From: [REDACTED]
To: [Metrowest1](#)
Subject: Issue Specific Hearing 2, Day 1, Agenda item 4 - Permanent Public Right of Way Diversions and Alternatives
Date: 11 January 2021 22:08:41

Pill & Easton-in-Gordano Parish Council

NATIONAL CYCLE NETWORK
ROUTE 26 TEMPORARY DIVERSION
WORKS MARSH LANE

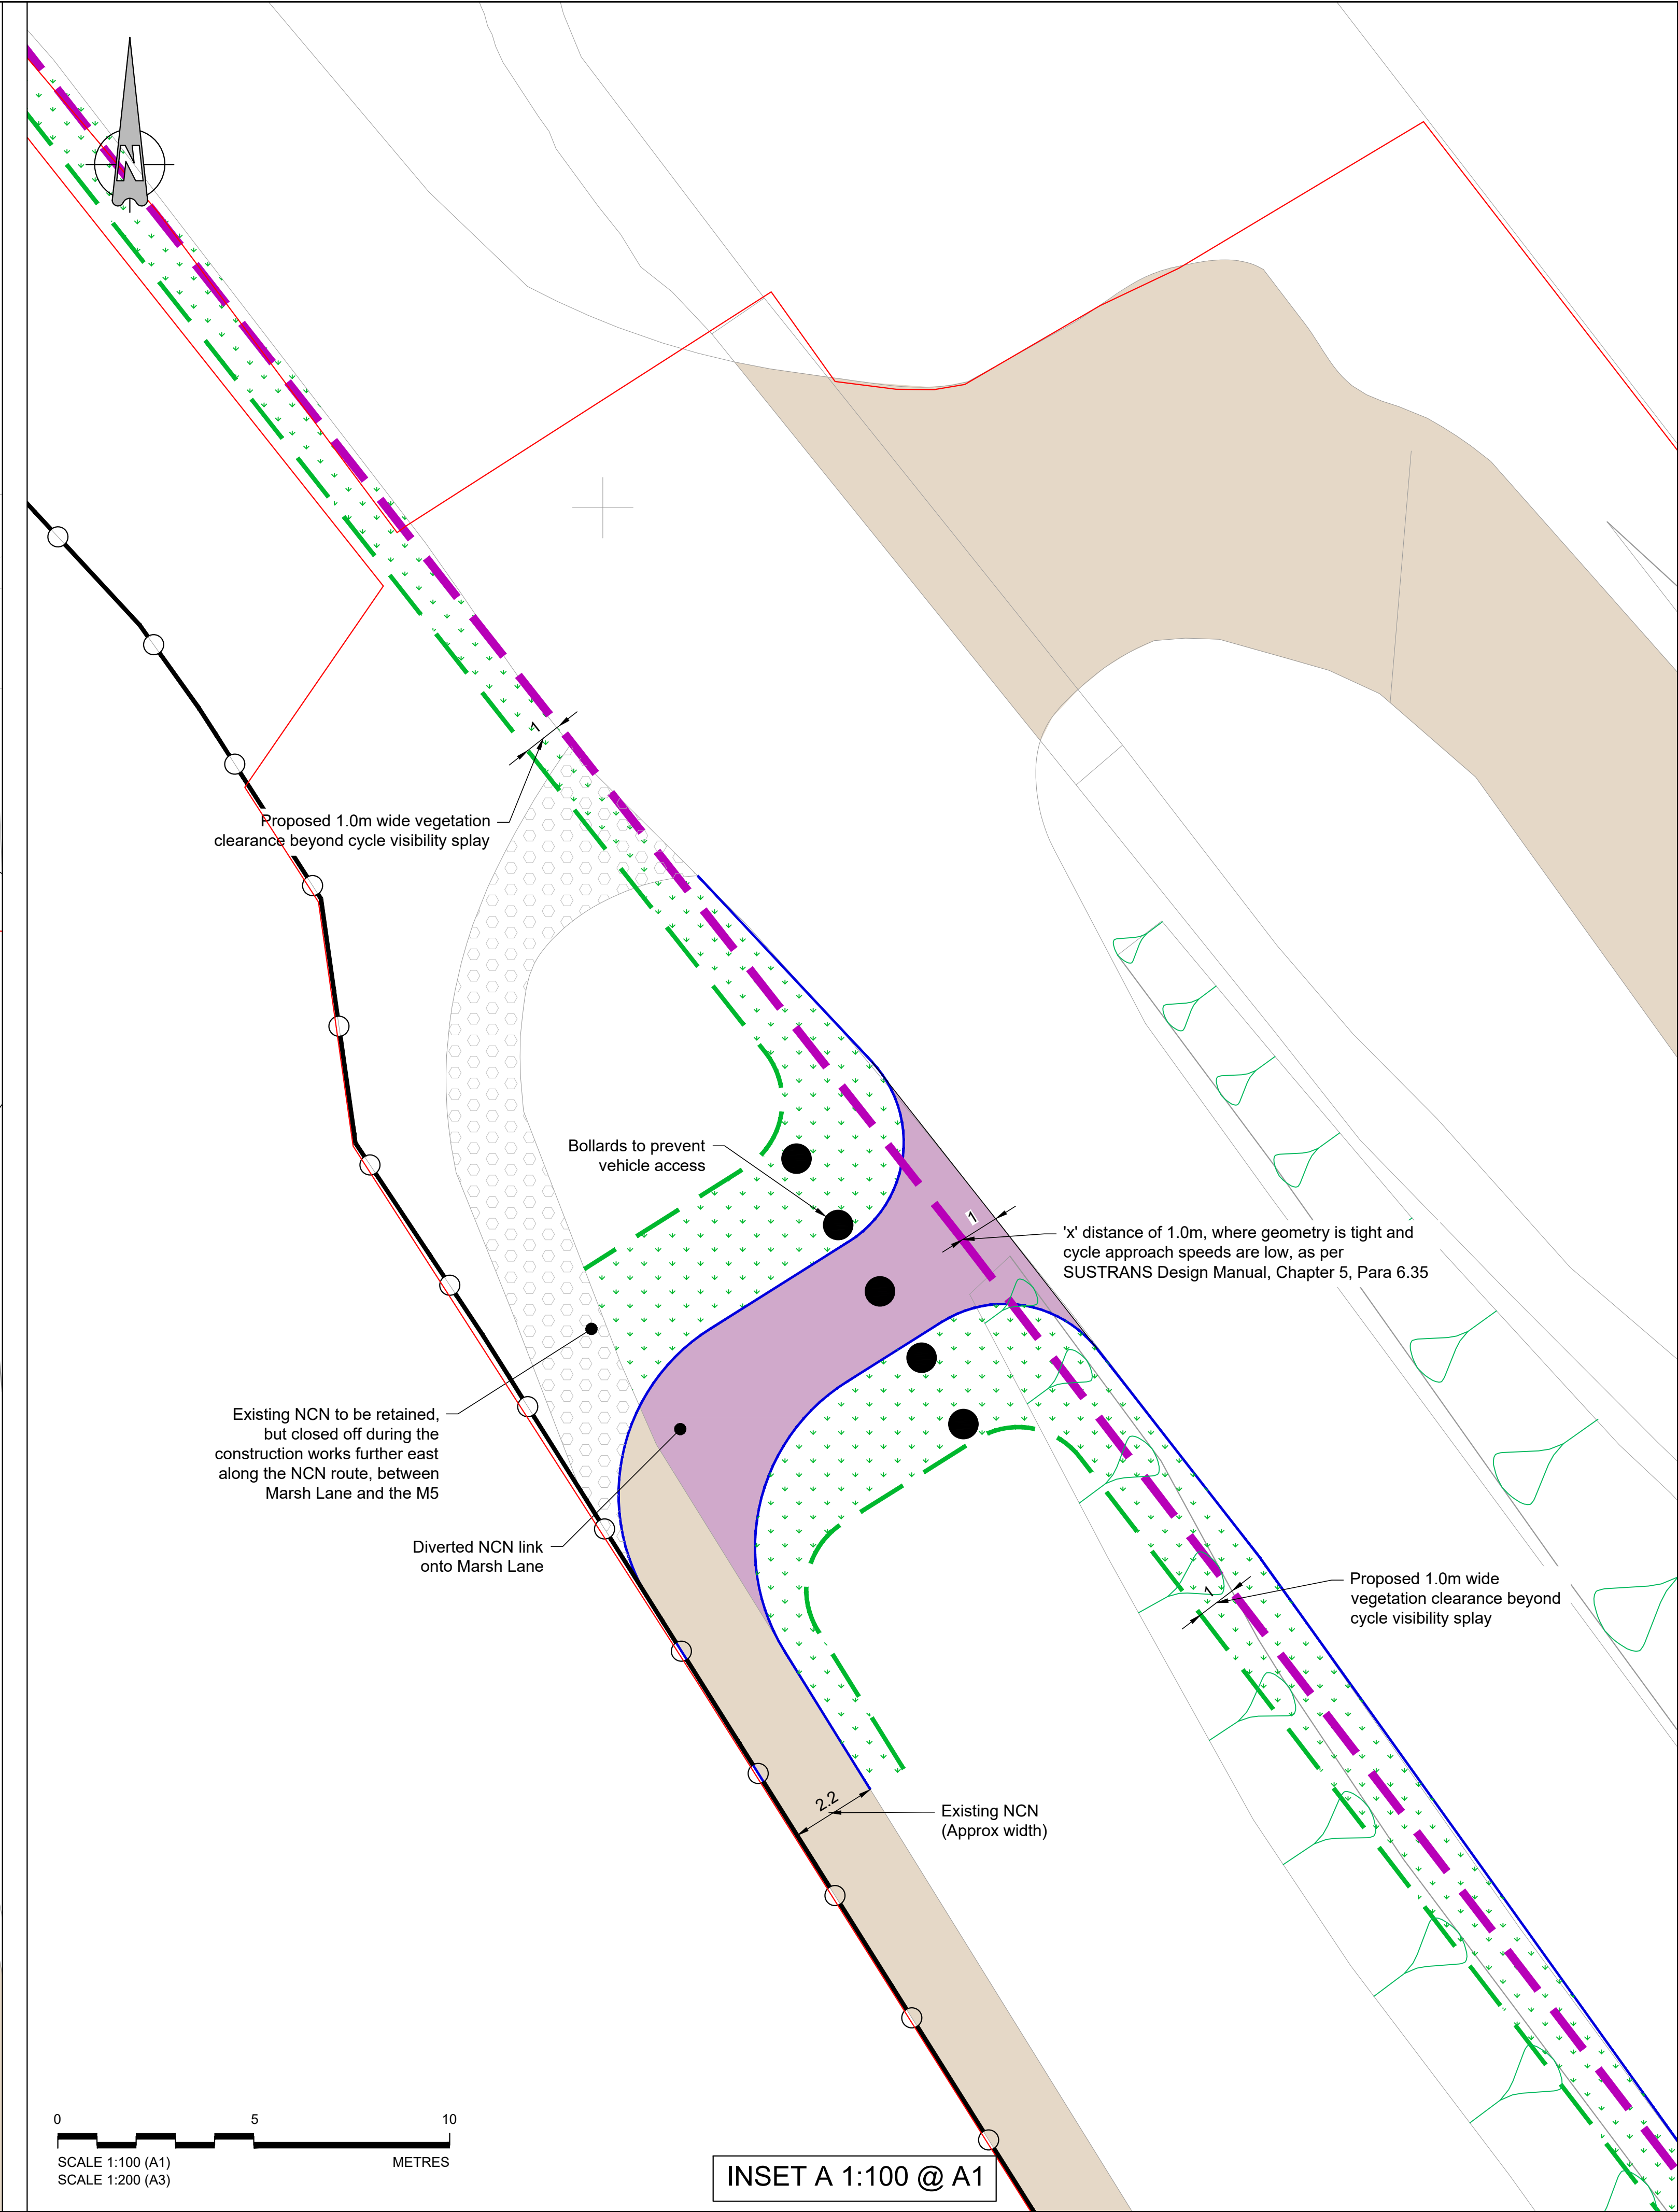
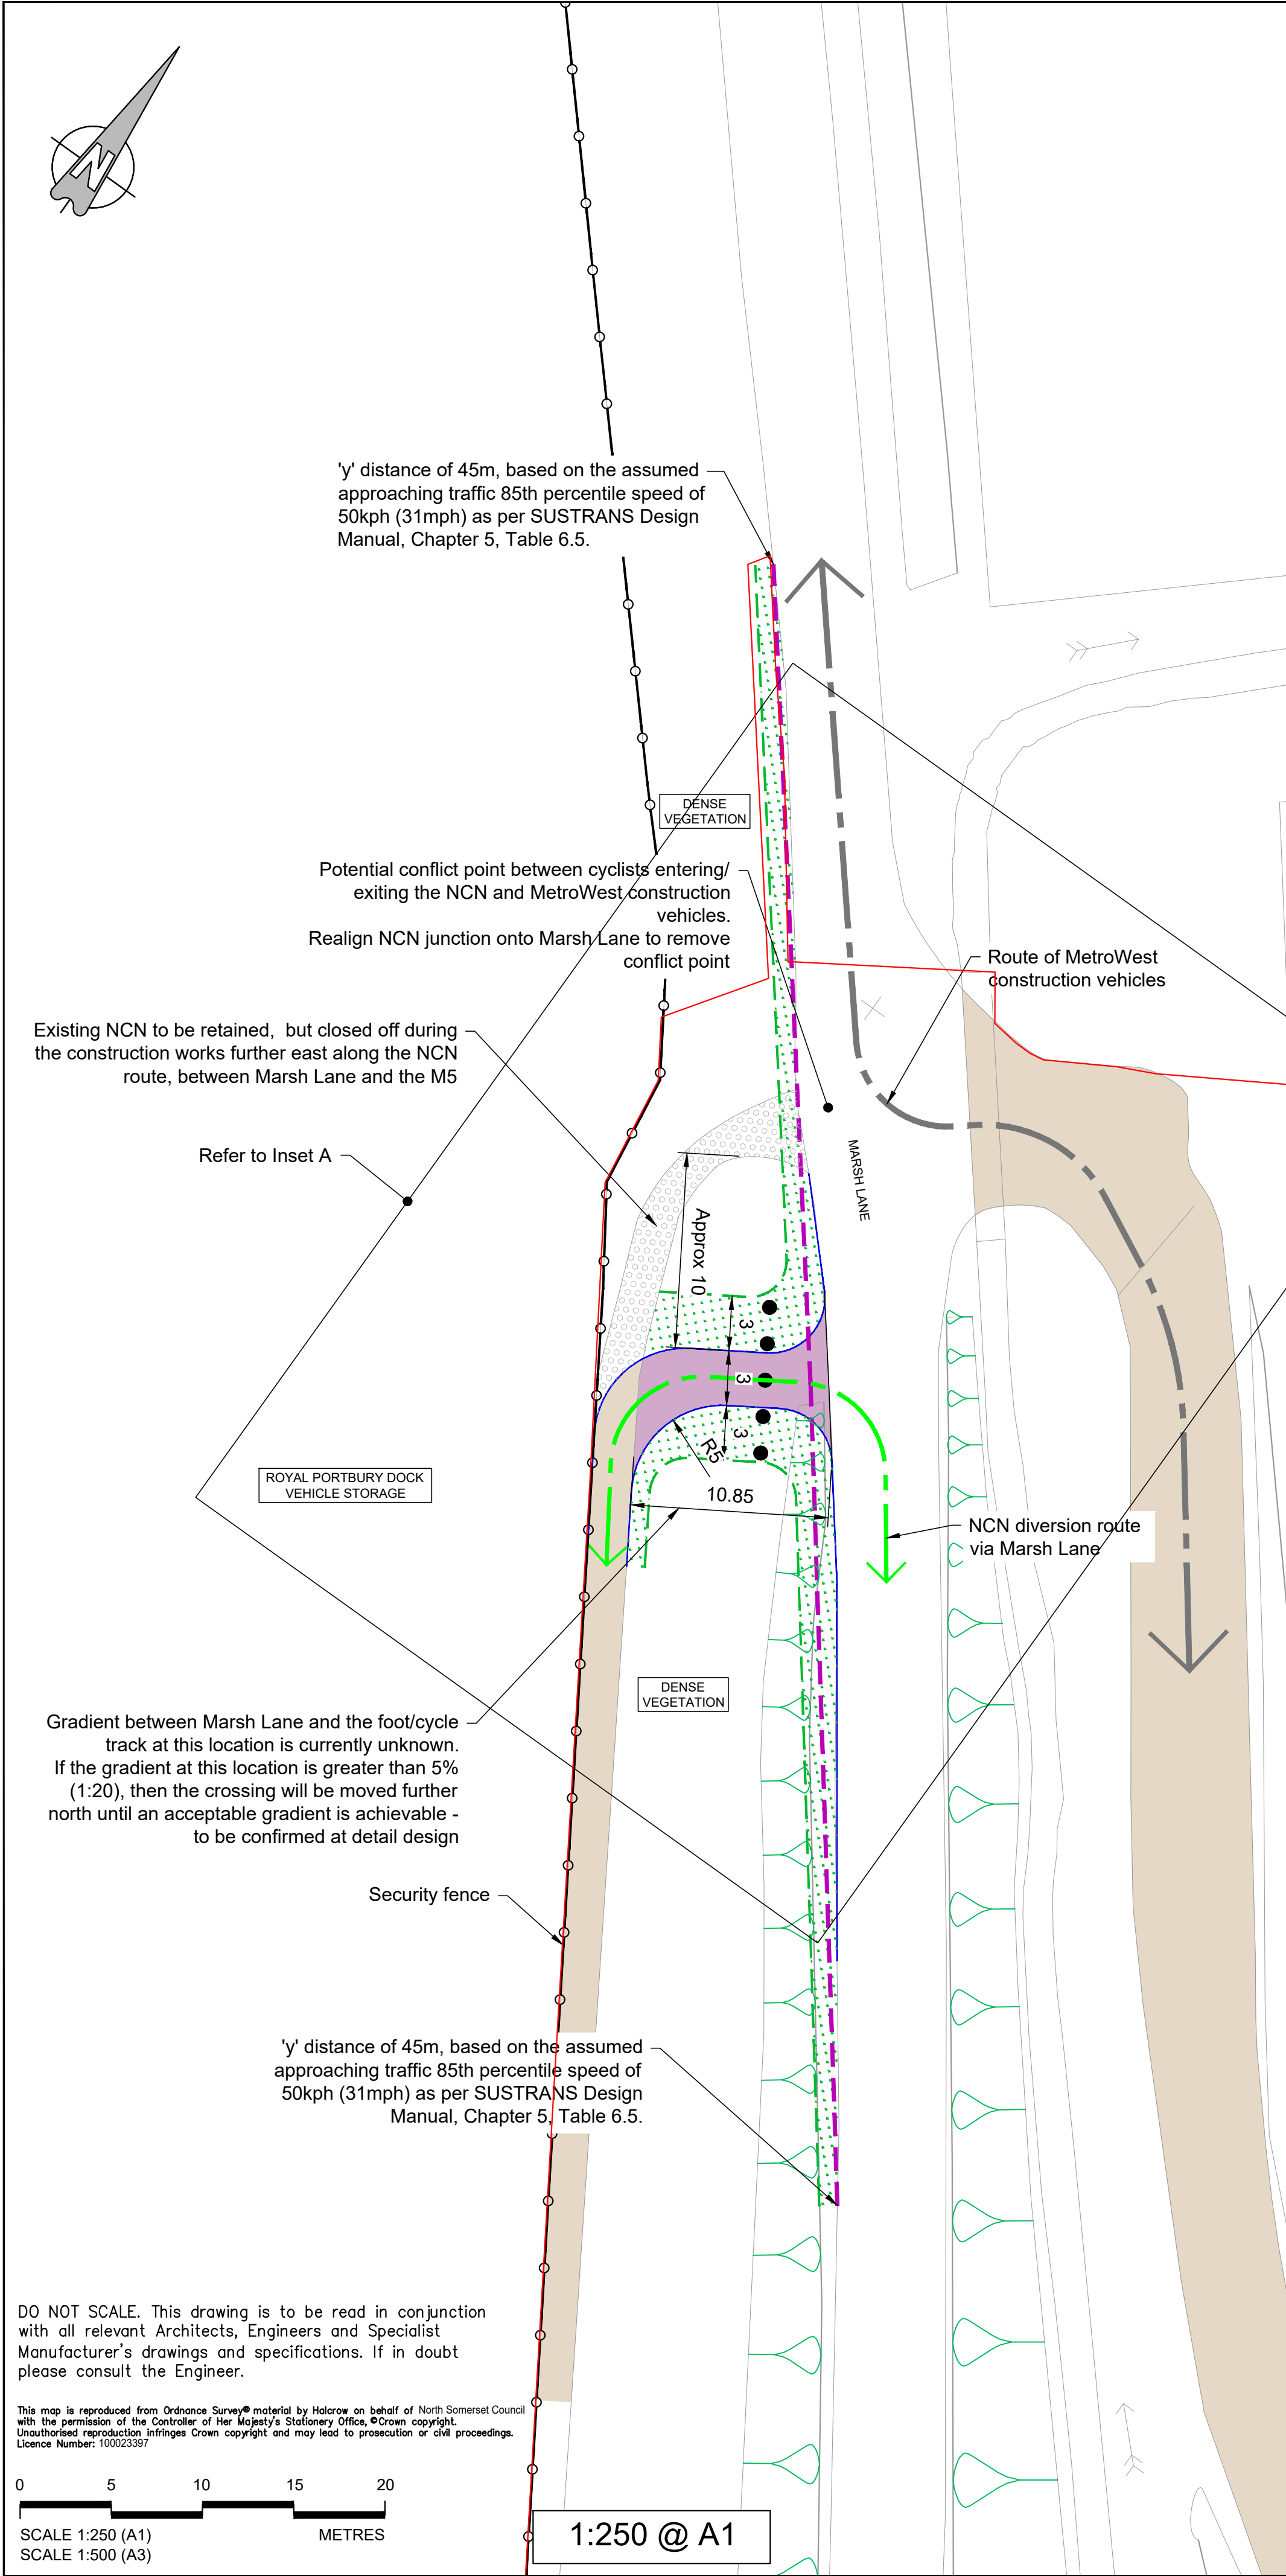
2. Proposed Diversion Route for NCN 26. I am also very concerned about the proposal to divert NCN26 southbound from its junction with Marsh Lane to the junction with Church Road in Easton-in-Gordano. I disagree with the view expressed today by the Applicant's representative that because Marsh Lane is a minor route the proposed diversion would not significantly increase the hazard to users of the diverted section of NCN 26. I walk this road several times a week and often cycle along it to reach NCN26 from my home. Almost the entire stretch of the diversion route is subject to a 40 mph speed limit, dropping to 30 mph just before reaching Church Road. Arguably, this is still too high. Until recently the speed limit was 60 mph and a significant number of drivers continue to treat it as such. There is also a hump-backed bridge on a bend over the railway about 100 metres south of the NCN26 junction with Marsh Lane. Finally, Marsh Lane is narrow at this point and there is no footpath for a distance of 100 metres either side of the bridge. At certain times of day, the road is also relatively busy with local traffic. This combination of factors makes the road hazardous and, although I know this stretch of road well and am keenly aware of the dangers, I ride or walk along it with considerable trepidation. As mentioned by Mr Berry, NCN26 is becoming increasingly busy, and not just because of the pandemic. Very often there are groups of cyclists, including small children/novices, who are perfectly safe on the current route of NCN26. There is a short road crossing at Marsh Lane to negotiate but, since there is reasonable visibility in both directions, this is safe for all NCN26 users. However, I think it would be incredibly unwise to direct cyclists, perhaps unknowingly, southbound down Marsh Lane and thus having to mix with fast moving traffic for several hundred metres on a narrow road with a blind crest over the bridge. In my opinion a lot more work would have to be done to make this diversion route safe until the permanent route could be restored at the end of the two year construction period. I am thinking here in

terms of aggressive speed reduction measures such as speed humps and warning signage to impress on drivers the need to drive slowly and exercise extreme caution. I have seen no such active measures proposed in the DCO, other than an annotation on a chart that “no construction traffic shall use this route” for that section of Marsh Lane.
